ENG-SF20015-R3-Plat-redlines.pdf Markup Summary

Subject: Callout
Page Index: 1
Date: 6/17/2021 3:10:44 PM
Author: dsdrice
Color: ■
Layer:
Space:
Page Label: [1] 2518801FP-COVER 1

RADIAL BEARING TABLE	
LINE	BEARING
RB1	S42°45'42"E
RB2	S65°48'10"E
RB3	S39°39'02"W
RB4	N39°51'05"W
RB5	N31°35'07"E

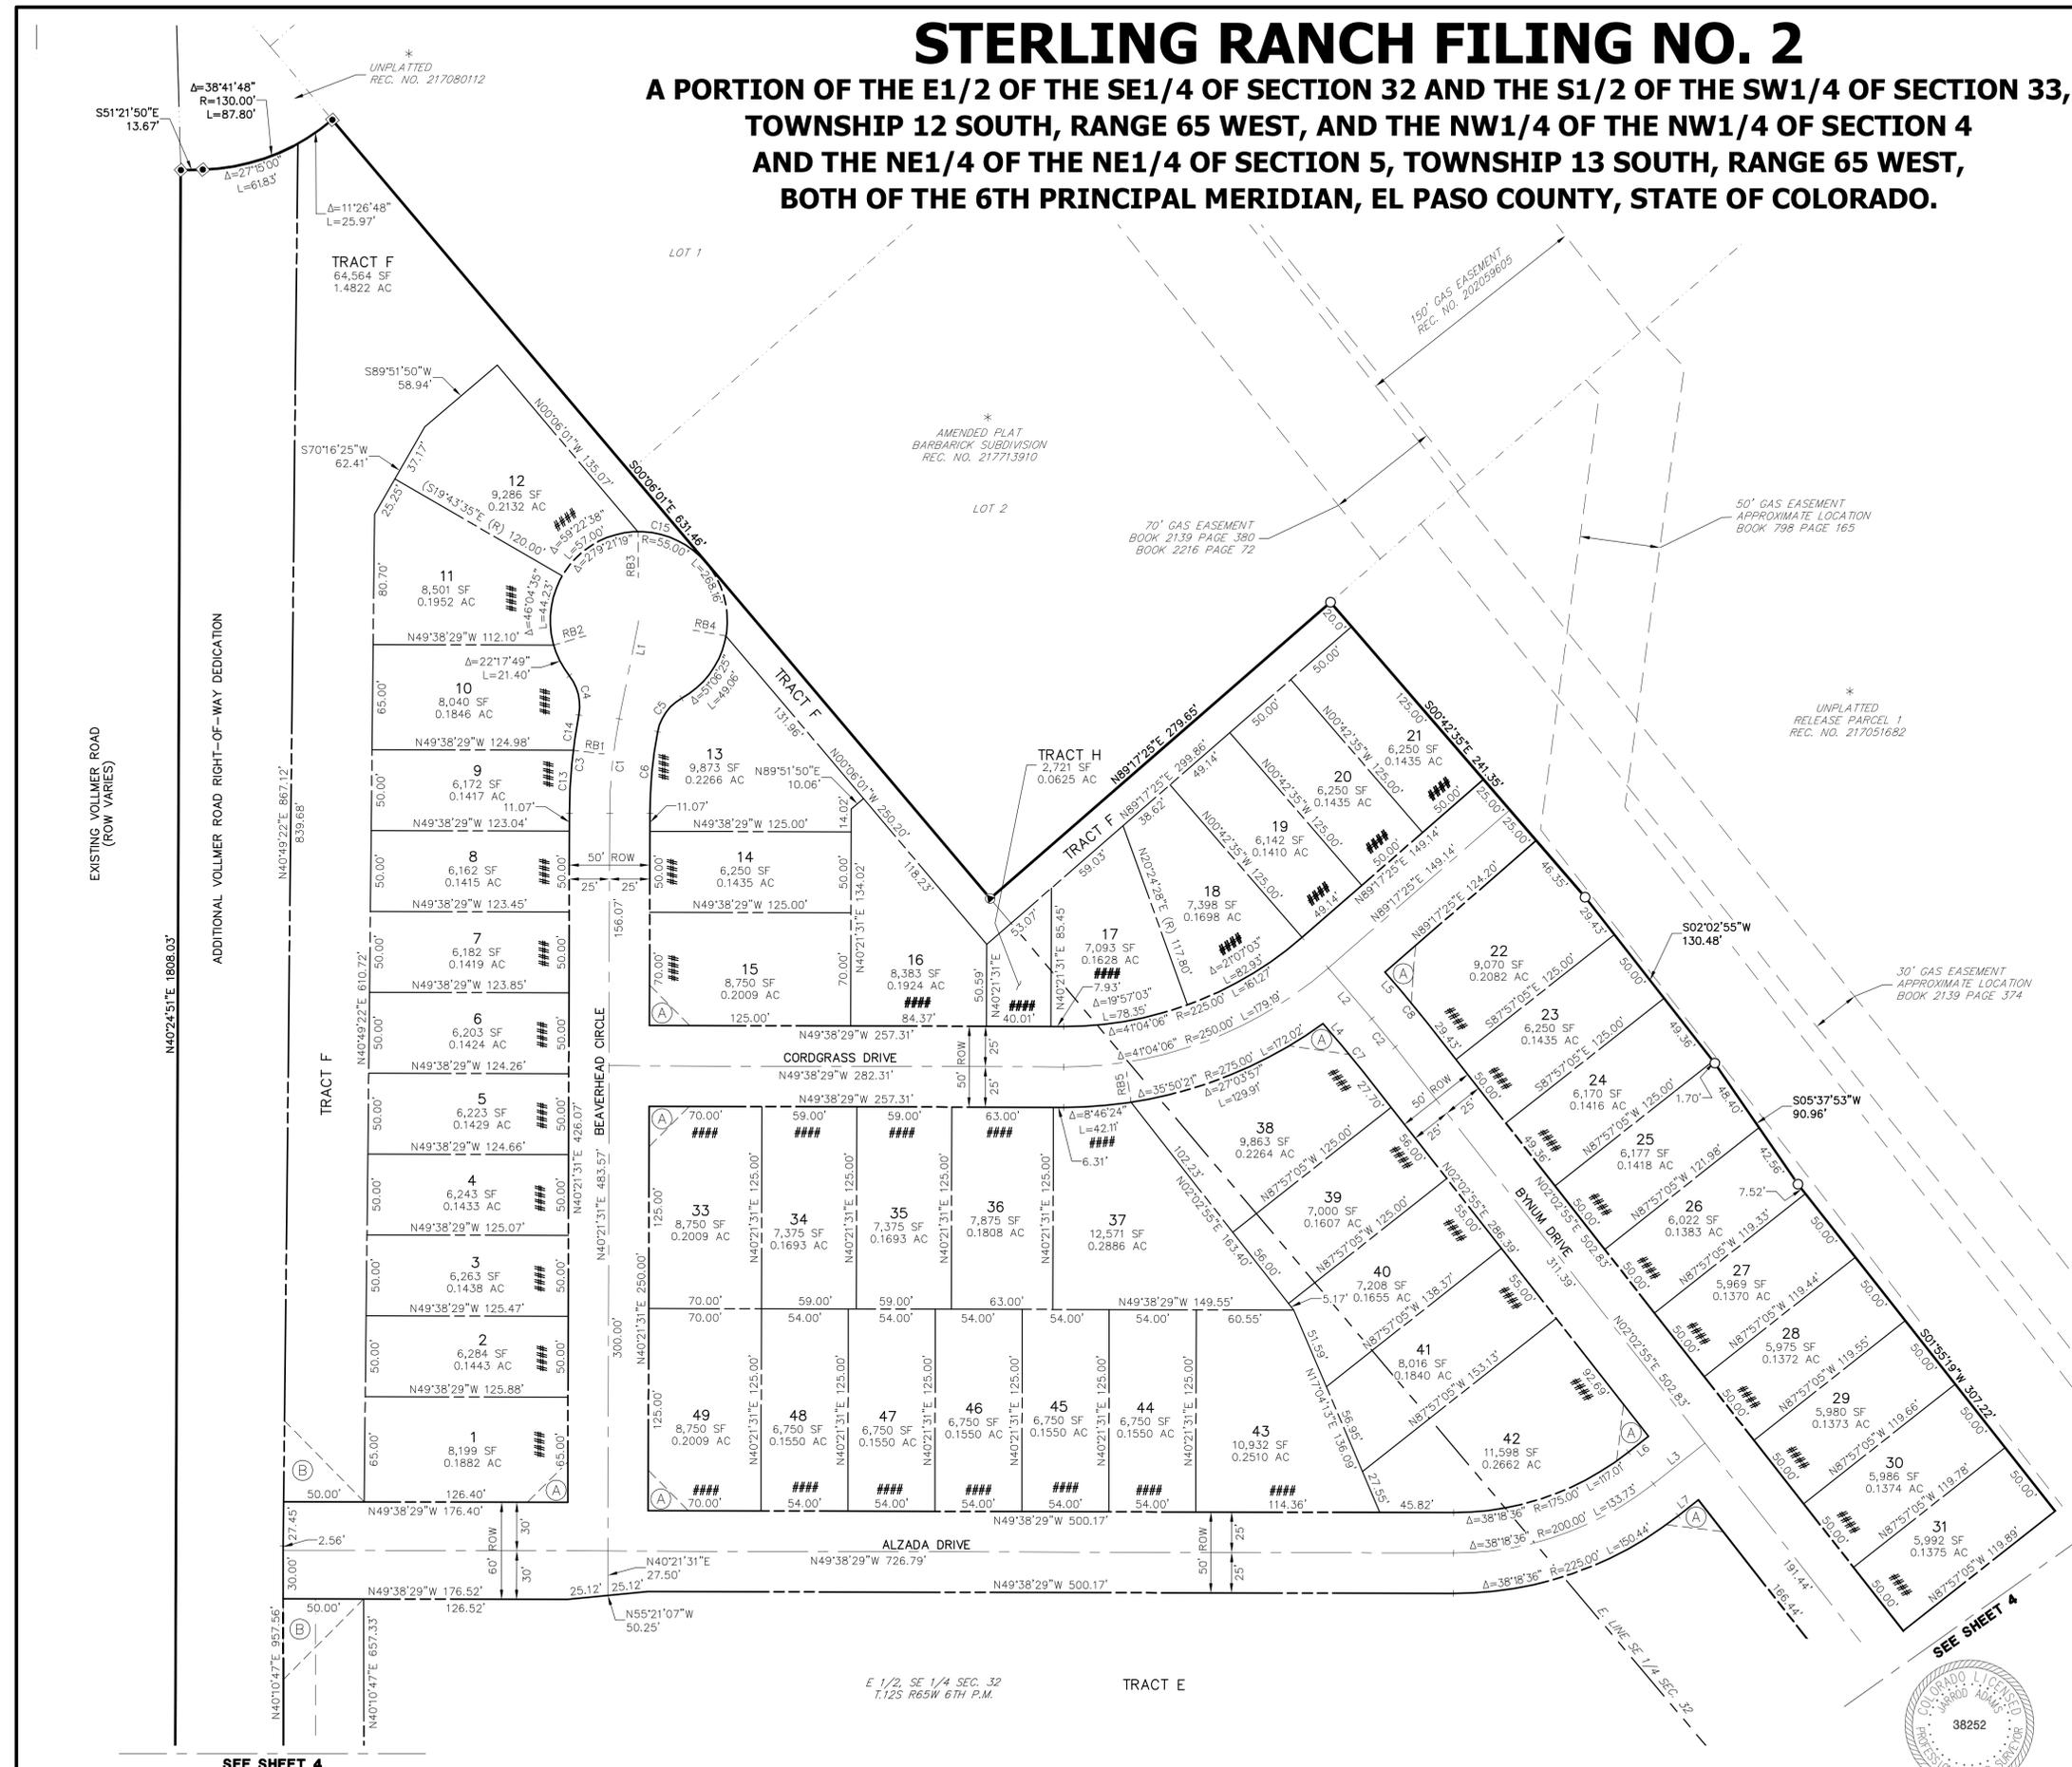
Plat south portion of Marksheffel Road (and the necessary ROW for Vollmer Rd. to avoid a ROW plat) as tracts.

Is Pond W5 tract being platted with Marksheffel Road?
